Our ref: STH07/00342/05
Contact: Rachel Carocci 4221 2423
Your ref: MP05_0024 MOD 4

**MODIFICATION REQUEST MP05_0024 MOD 4 – LOTS 117 & 118 DP 1226471, HIGHVIEW DRIVE,
DOLPHIN POINT – RESIDENTIAL SUBDIVISION**

Figure 3: Dolphin Point Road Link connection to the Princes Highway (source: Nearmap)

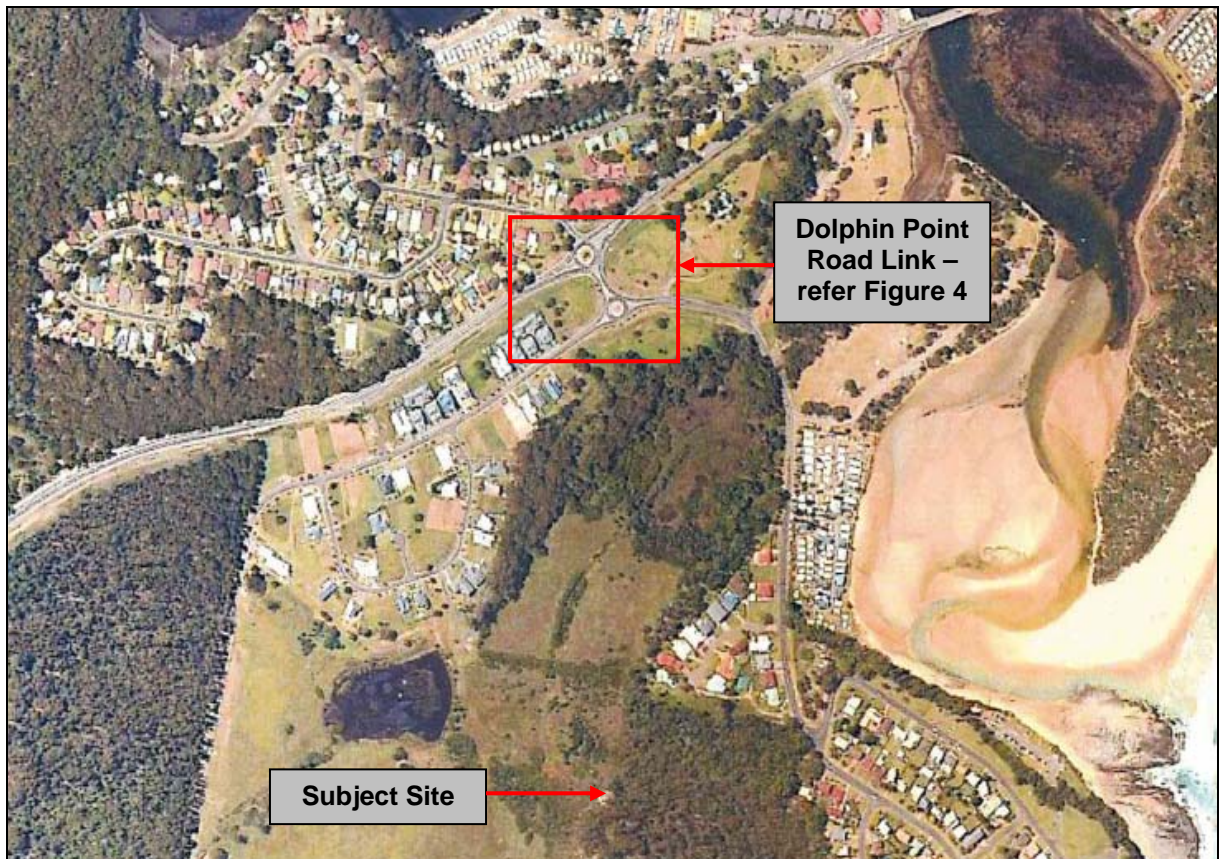
RMS recognises that the applicant is seeking to have condition B21 removed from the conditions of consent, and is requesting RMS' support for the removal. Ultimately, this is a decision for Council as the requirement to provide a left-turn approach lane to the Princes Highway was a Council condition.

However, RMS believes that there would be merit in the submission of justification, such as a traffic analysis and SIDRA modelling, to demonstrate that the works are not required.
